KIRKLEES METROPOLITAN COUNCIL INVESTMENT & REGENERATION SERVICE

DELEGATED DECISION TO DETERMINE APPLICATIONS FOR CONSENT, AGREEMENT OR APPROVAL REQUIRED BY CONDITION

Reference No:	2022/44/93858/W
Site Address:	railway line and associated land between, Huddersfield and Westtown (Dewsbury), within the Order Limits of The Network Rail (Huddersfield to Westtown (Dewsbury), Improvements Order 2022
Description:	Discharge condition 4, 5, 6, 8,10, 19 of the Deemed Planning Permission granted by the Department for Transport in relation to The Network Rail (Huddersfield to Westtown (Dewsbury) Improvements Order 2022
Recommending Officer:	Louise Bearcroft

Discharge condition 4, 5, 6, 8,10 and 19 of the Deemed Planning Permission granted by the Department for Transport in relation to The Network Rail (Huddersfield to Westtown (Dewsbury) Improvements Order 2022

Reproduced by permission of Ordnance Survey on behalf of HMSO. © Crown copyright and database right 2021. All rights reserved. Ordnance Survey Licence number 100040692.
Contains OS data © Crown copyright and database right 2021.

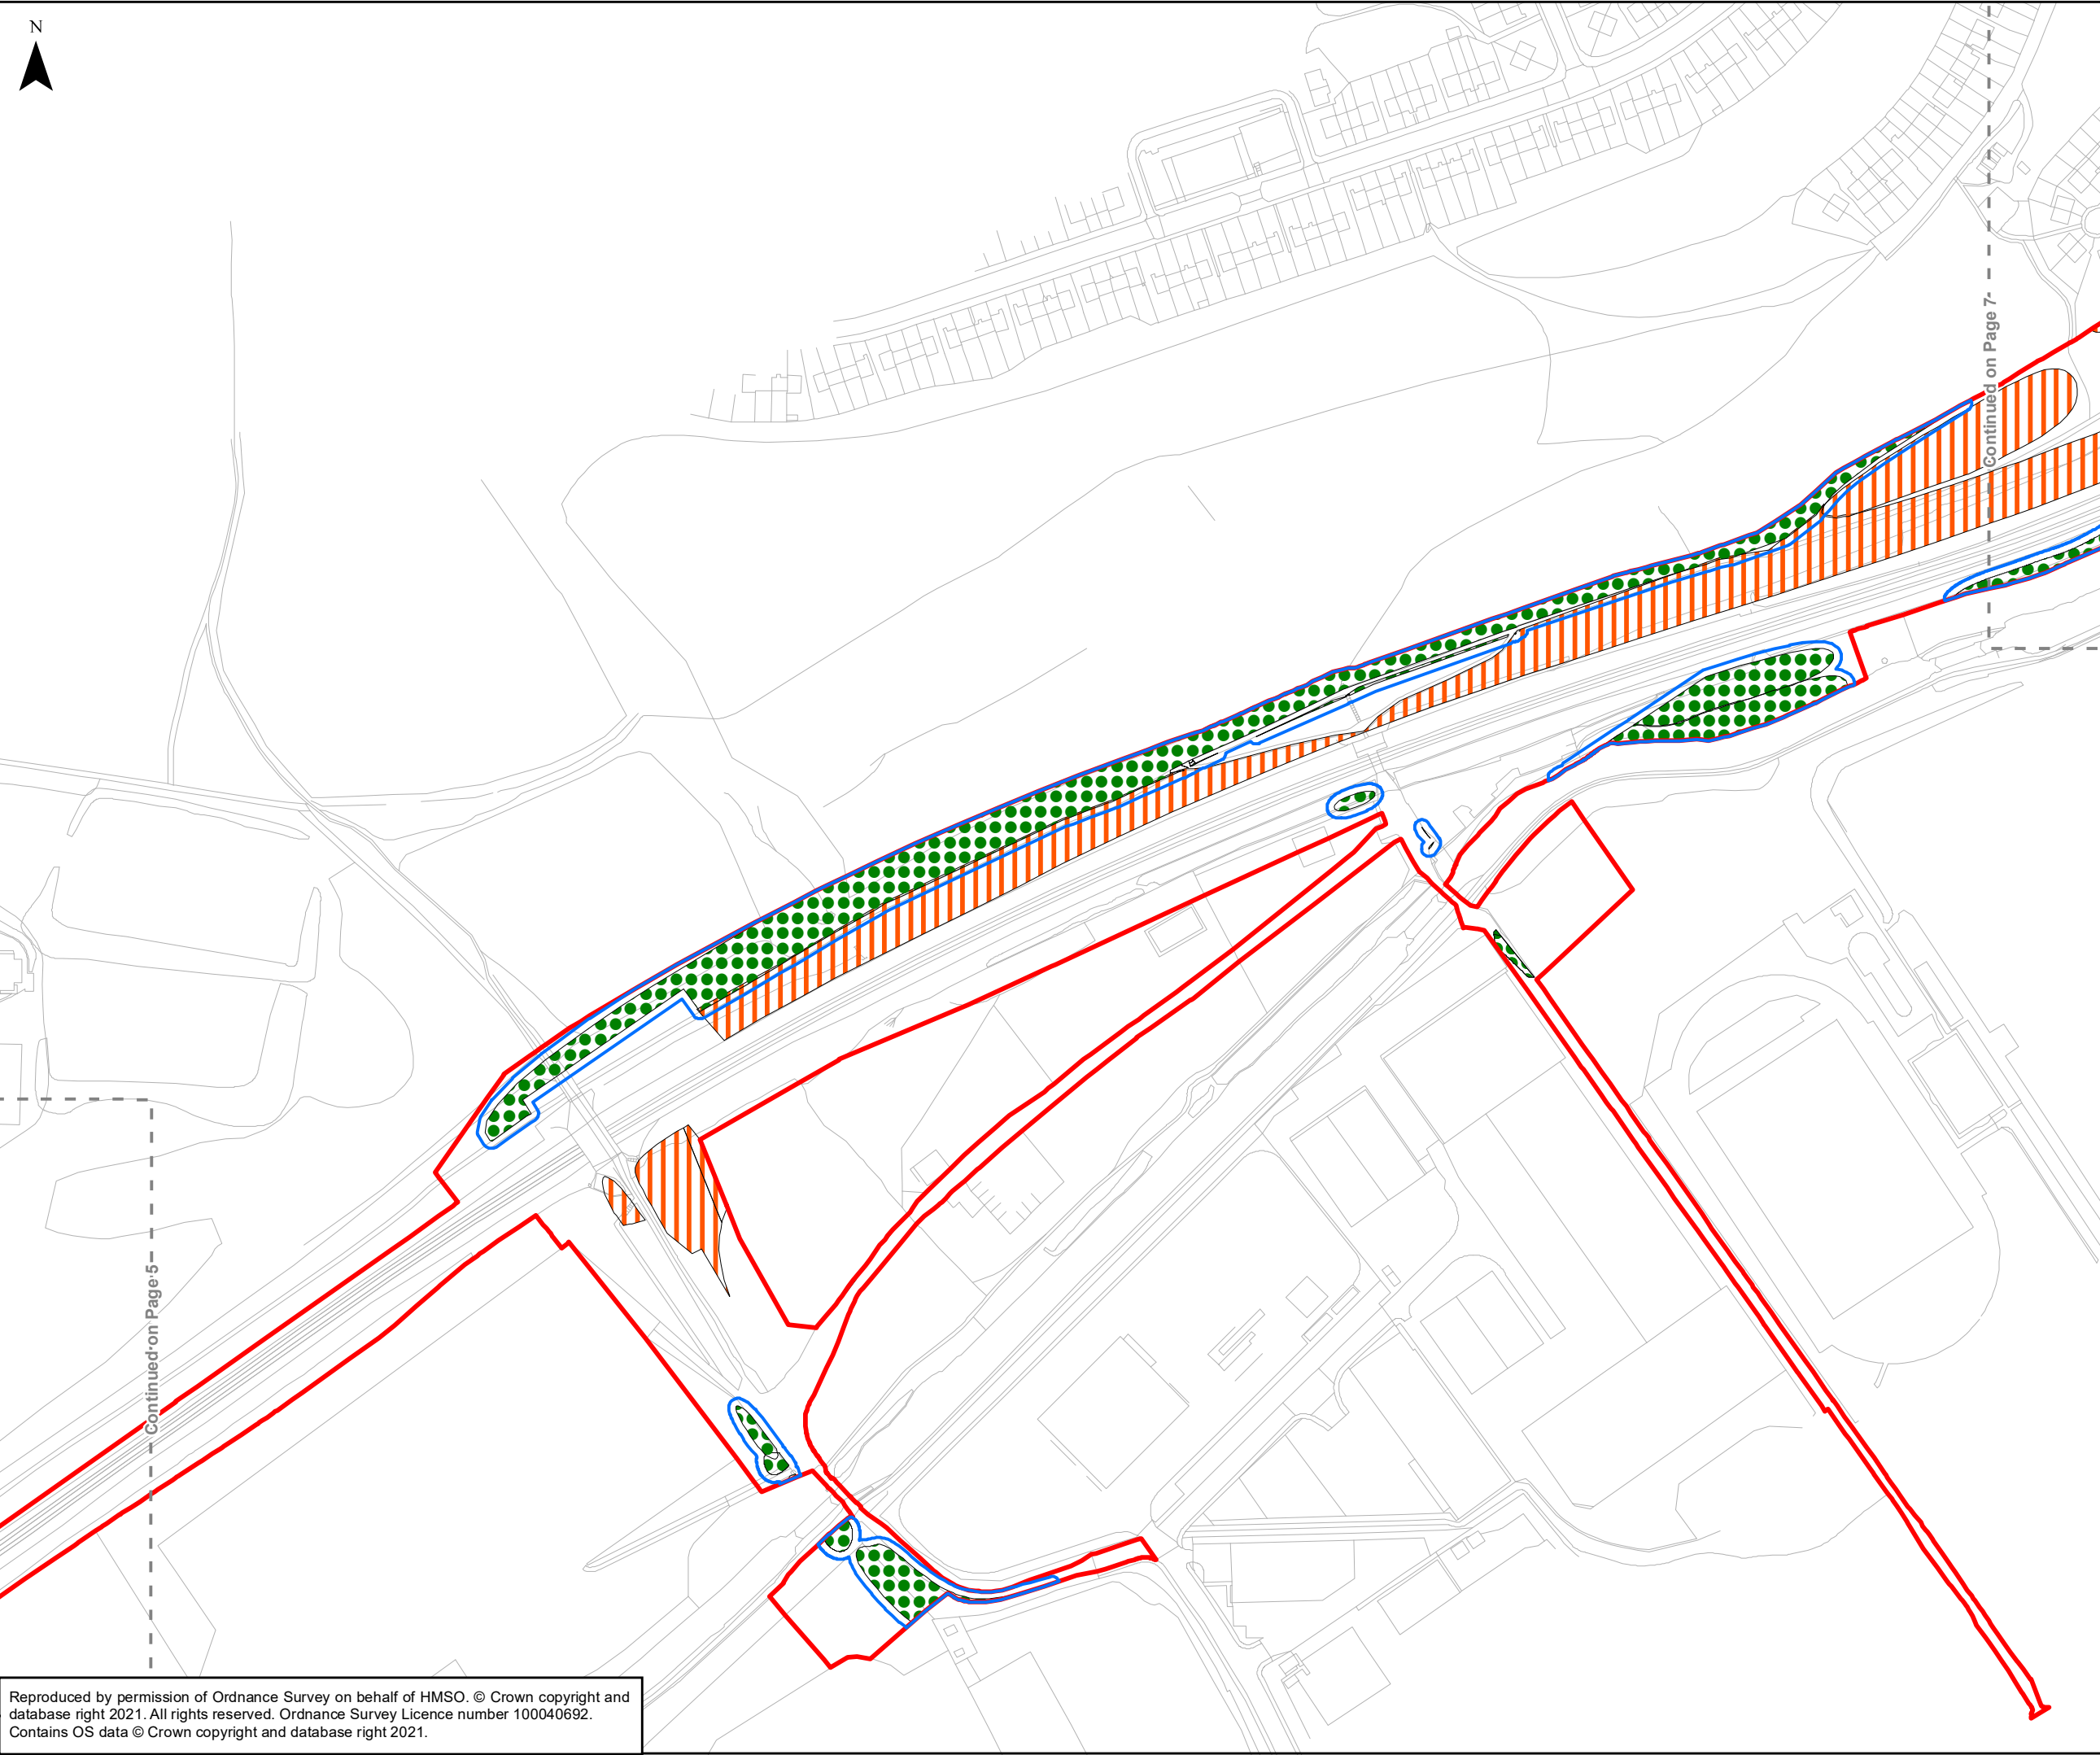
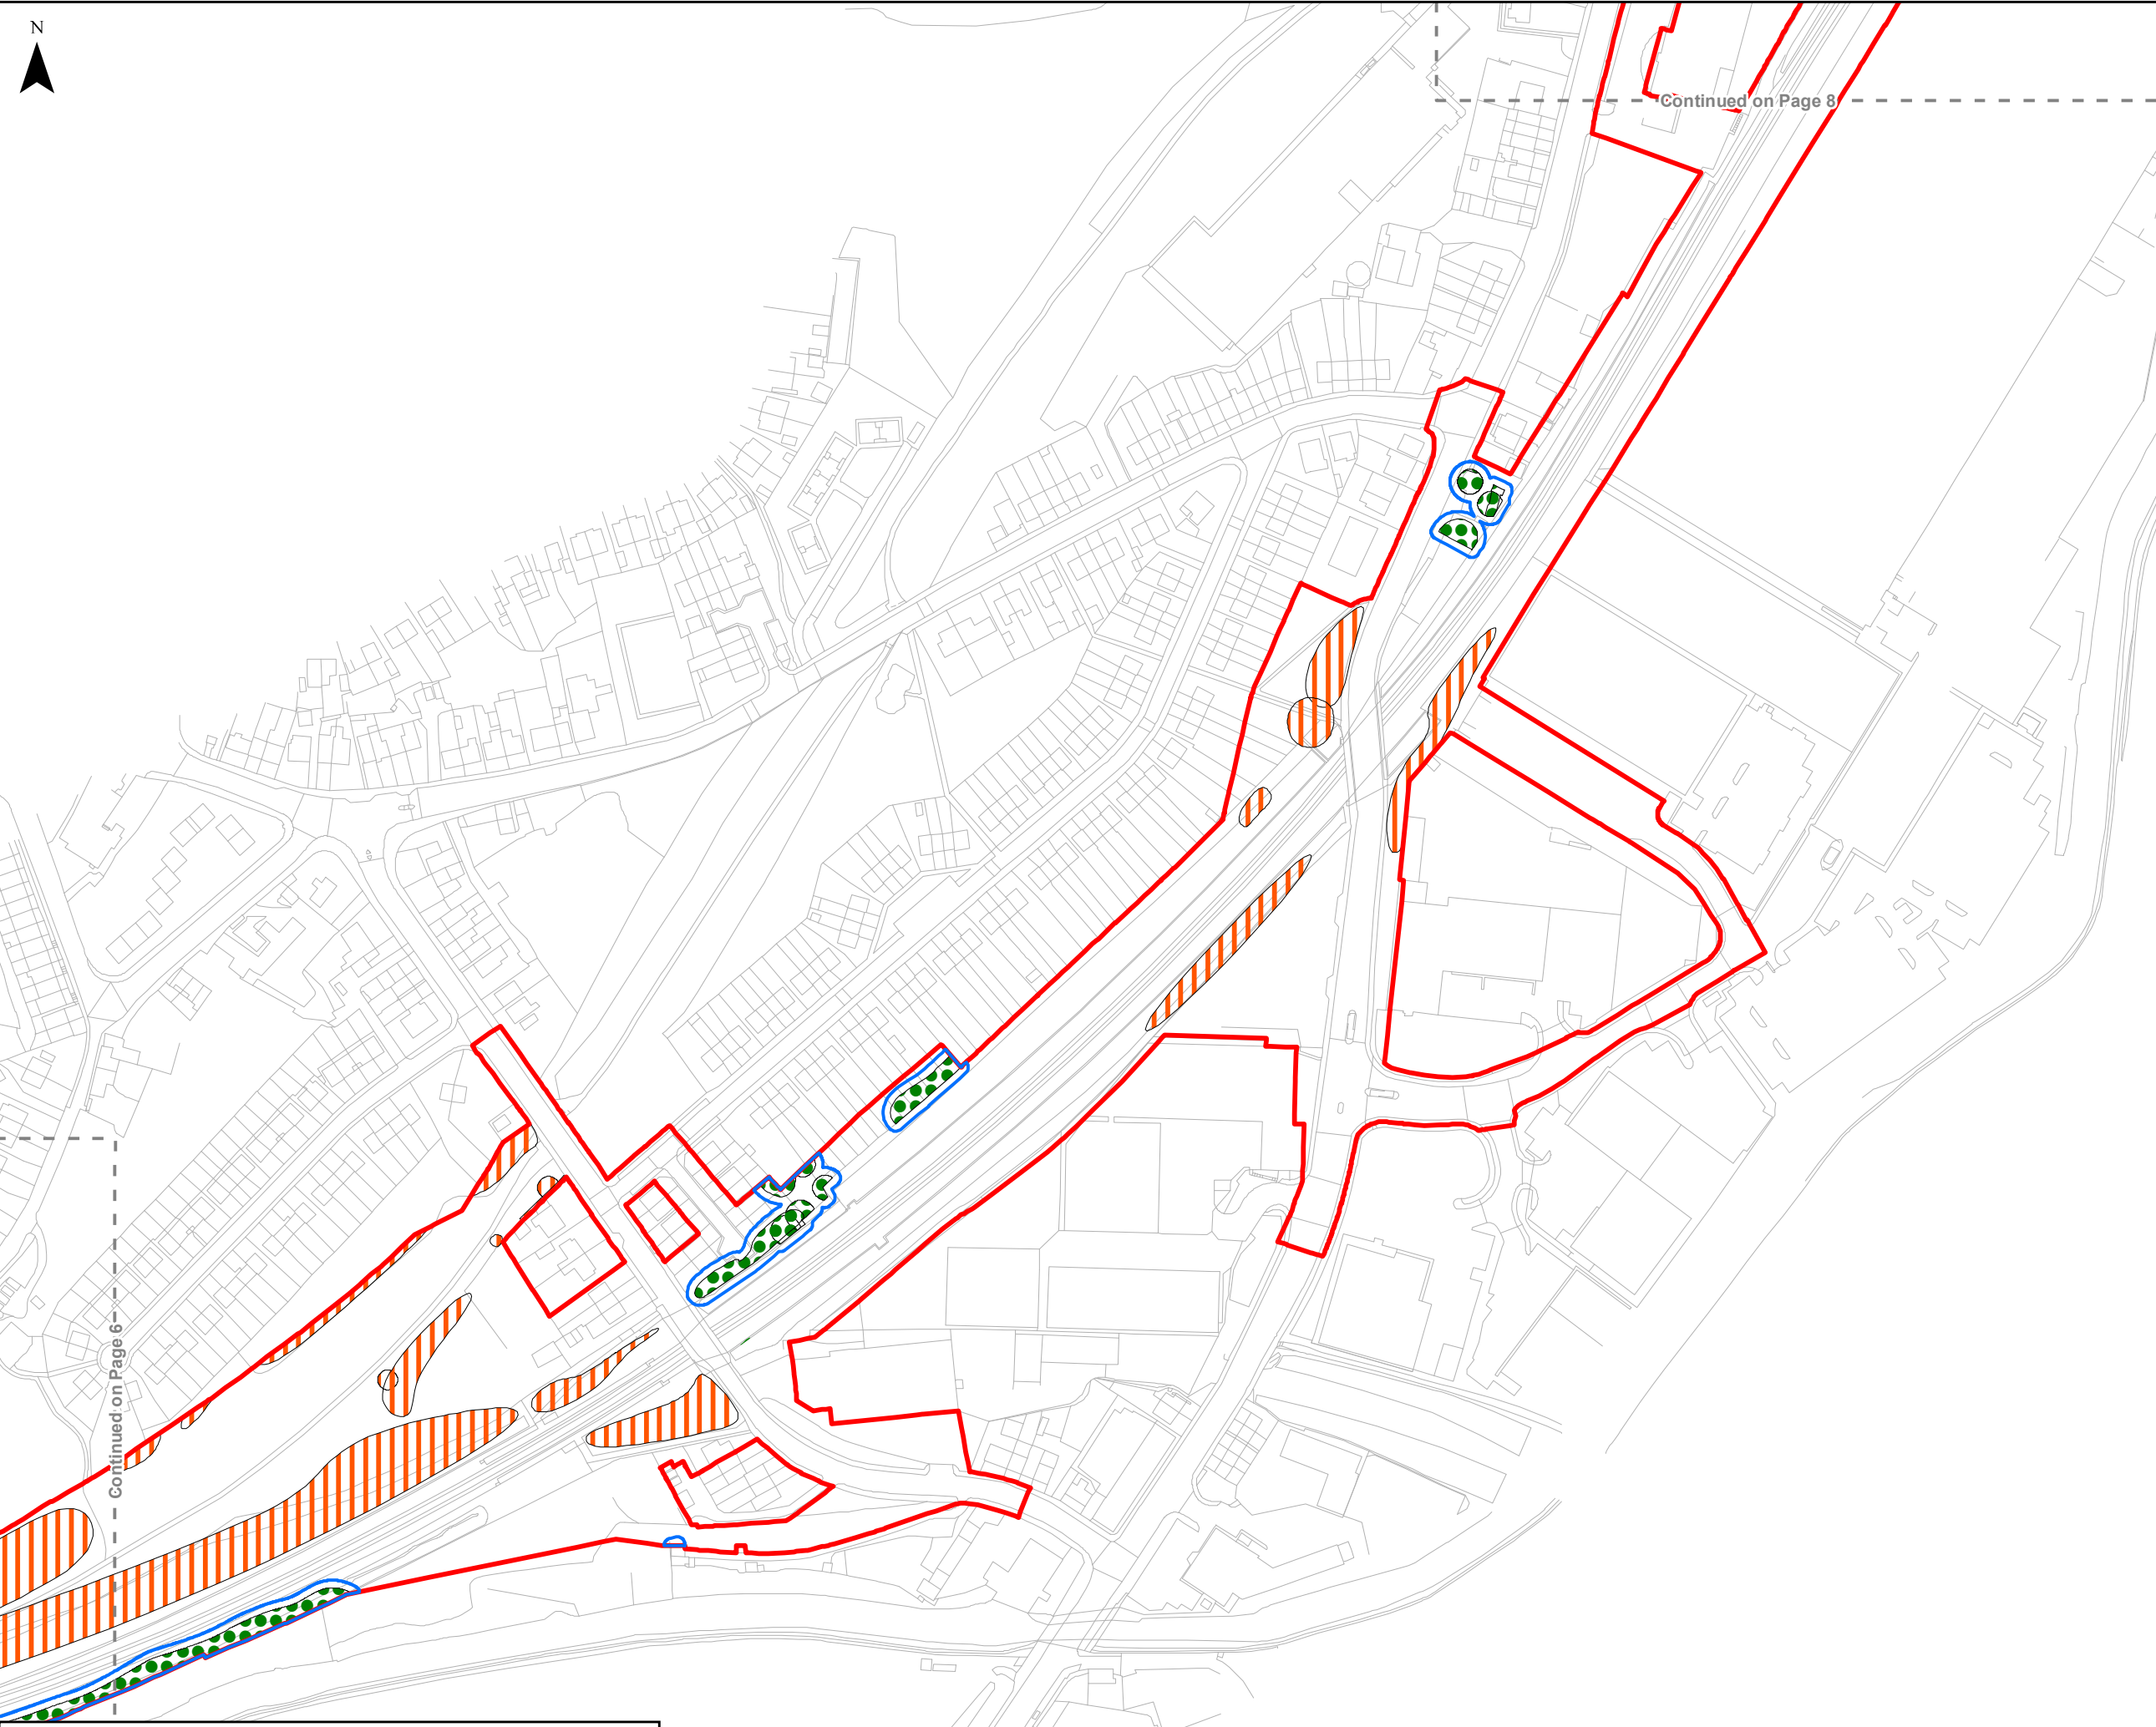
K.C Arboricultural Officer – With regards to condition 4 – Landscape and Ecological Management Plan Section 5 addresses trees to be retained on the site and trees in proximity to construction but offsite. The protection measures of installing fencing in accordance with BS5837 is in line with industry best practice and acceptable. Section 5 also states that each site will be subject to standalone Arboricultural Method Statements which will enable site specific needs to be incorporated into tree protection measures. I am satisfied that the

requirements of condition 4, with respect to tree protection, has been met by the submitted document: 151667-TSA-00-TRU-REP-W-EN-001179.

A plan of existing trees and tree features (such as groups of trees or woodland) to be retained and to be removed in accordance with BS5837 are provided and these seem to reflect the TWAO submission documents regarding tree loss (although there seems to be less tree loss around Ridings and Fieldhouse canal bridges which is welcome).

i) A plan of existing trees and tree features (such as groups of trees or woodland) to be retained and to be removed in accordance with BS5837(2012) - Section 5 details protection and mitigation for retained trees and Appendix A includes Scheme wide plans of the trees to be retained/removed shown hatched.

The aboricultural Officer notes that section 5 addresses trees to be retained on the site and trees in proximity to construction but offsite. The officer notes that the protection measures of installing fencing in accordance with BS5837 is in line with industry best practice and acceptable. Section 5 also states that

each site will be subject to standalone Arboricultural Method Statements which will enable site specific needs to be incorporated into tree protection measures. The Arboricultural officer is satisfied that the requirements of condition 4, with respect to tree protection, has been met.

Part a i) A plan of existing trees and tree features (such as groups of trees or woodland) to be retained and to be removed in accordance with BS5837(2012).
